18th June 2015

Ref. No. R/12/15/CLP

Loft Conversion - 31 Andrew Close

Drawing:
DESIGN PROPOSALS 2

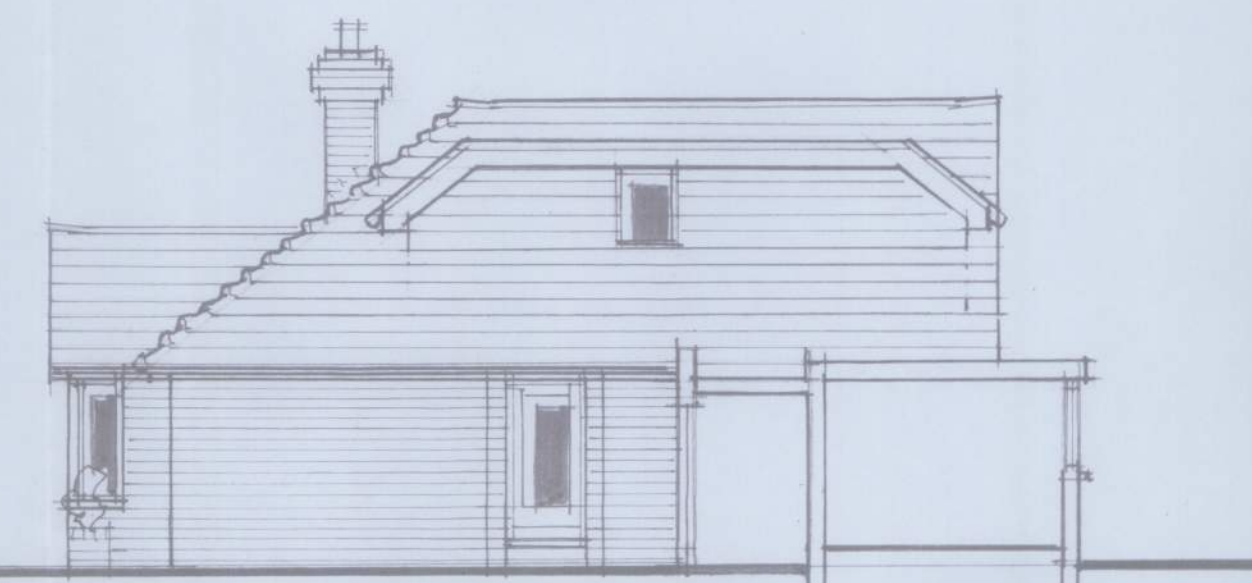
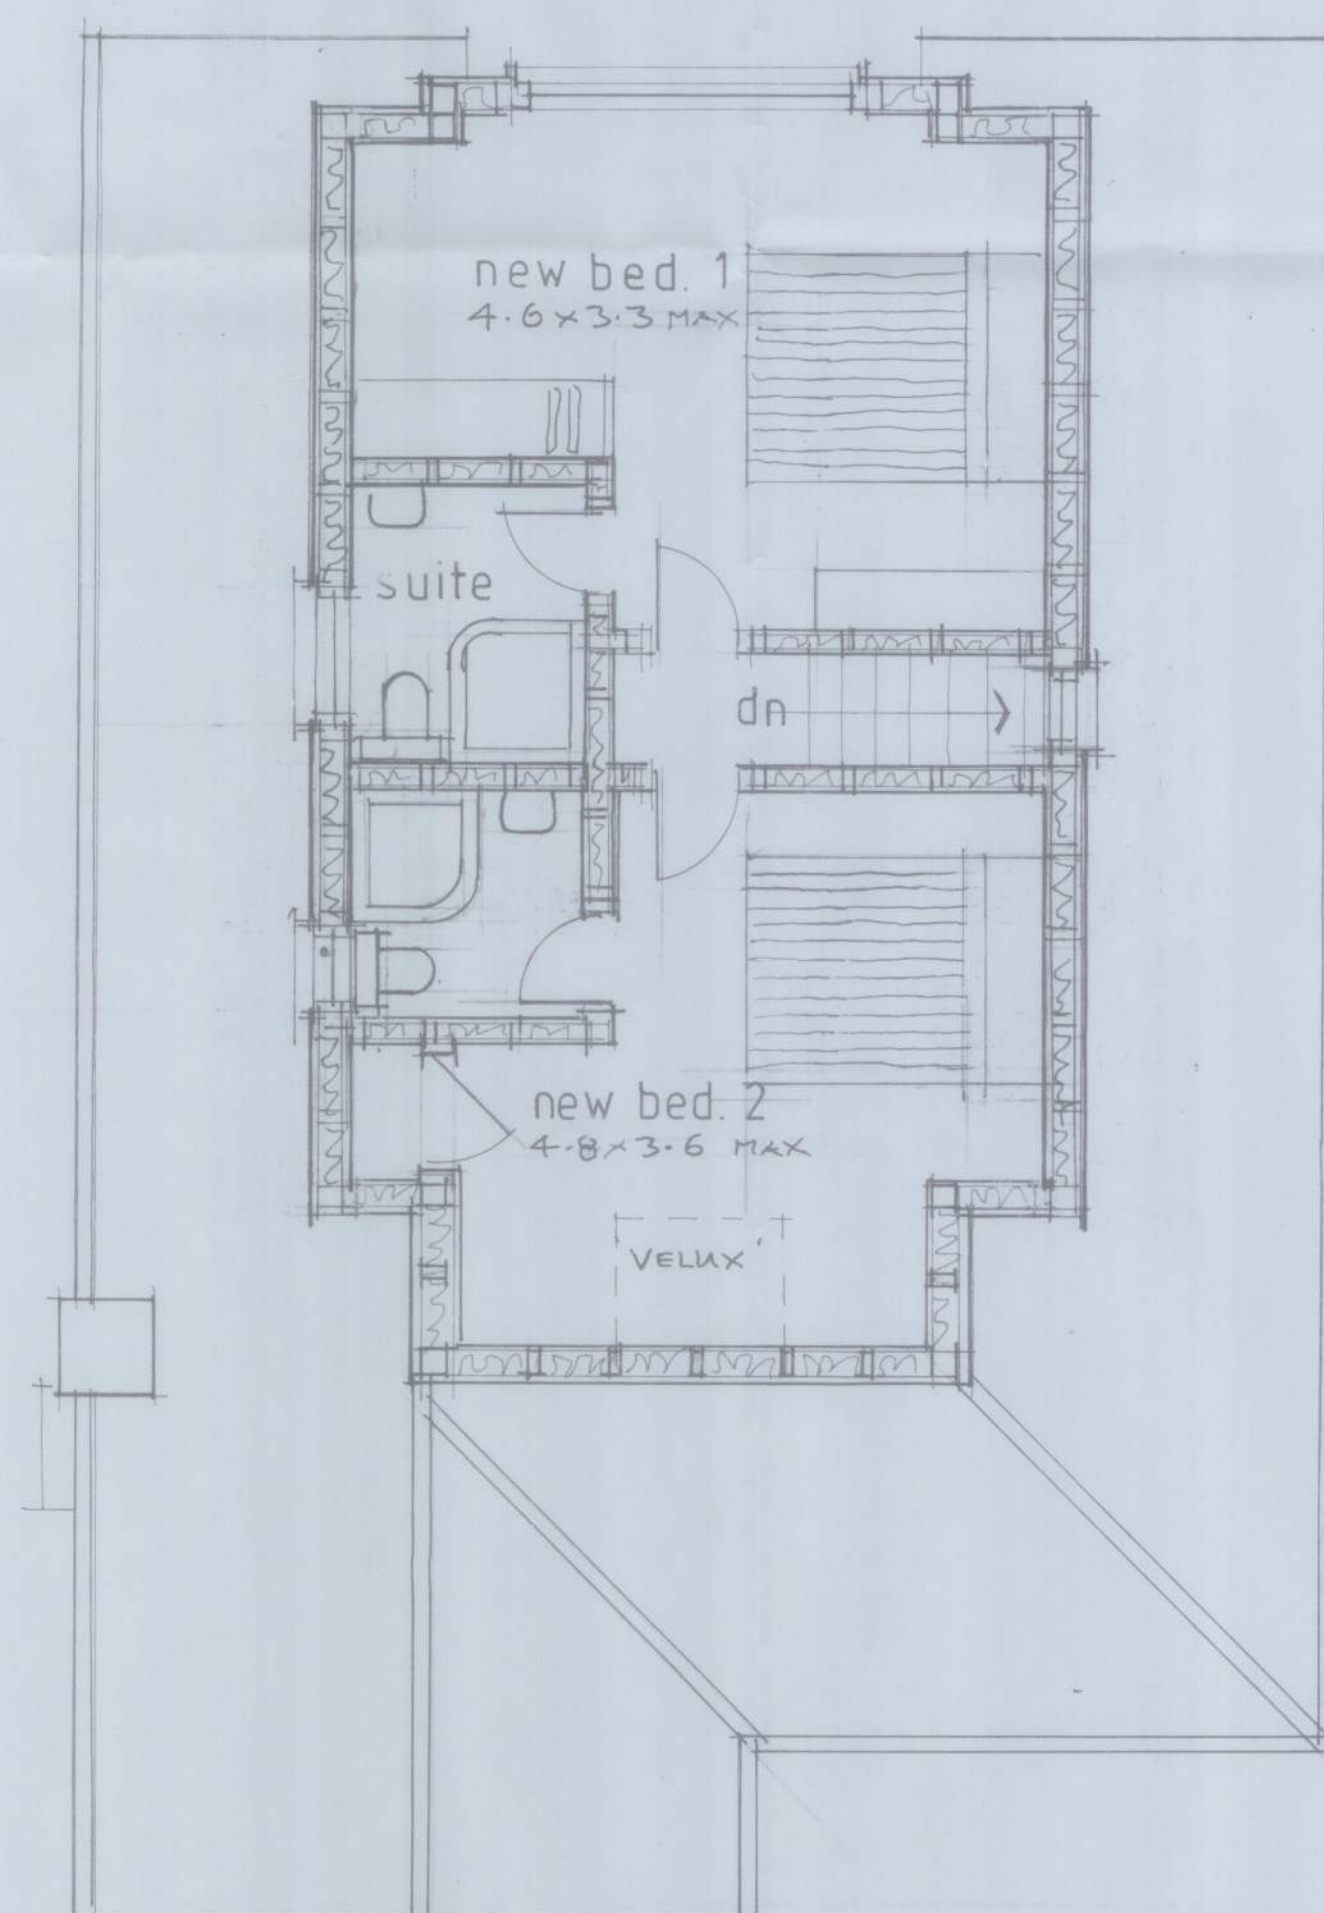
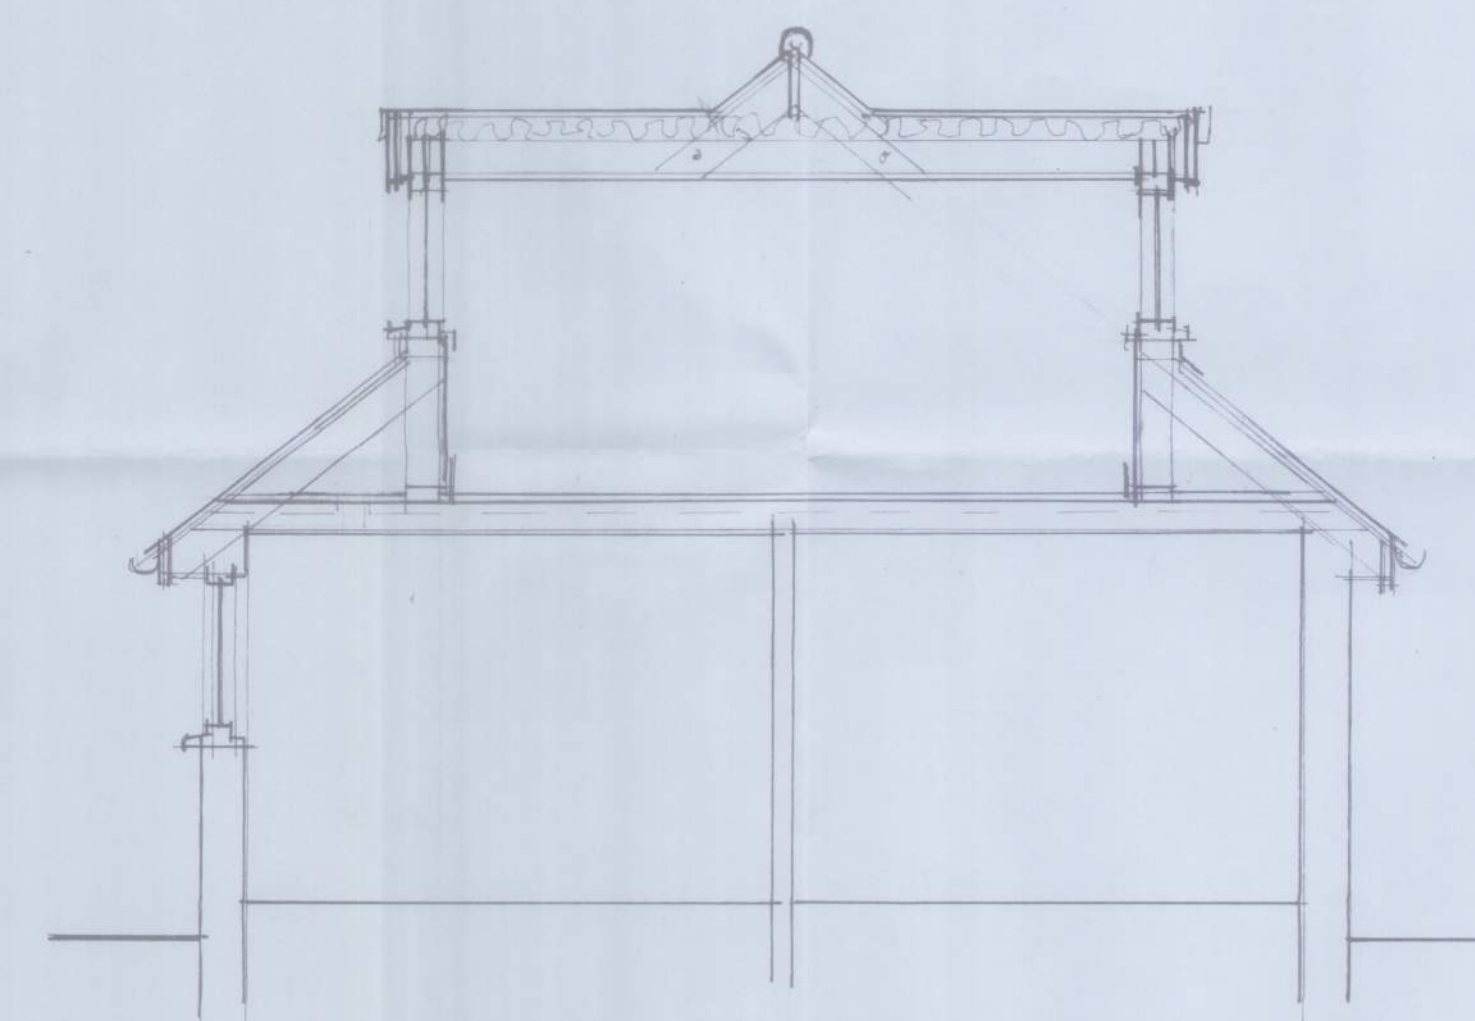
1. This will have an adverse effect upon the privacy of our bungalow from the roof windows to the north elevations.
2. The box type construction on the first floor will block a good amount of light into our kitchen for most of the day.
3. Please note our concerns about converting bungalows to Shaley type bungalows, it will reduce the bungalow stock for people to retire to in the future.
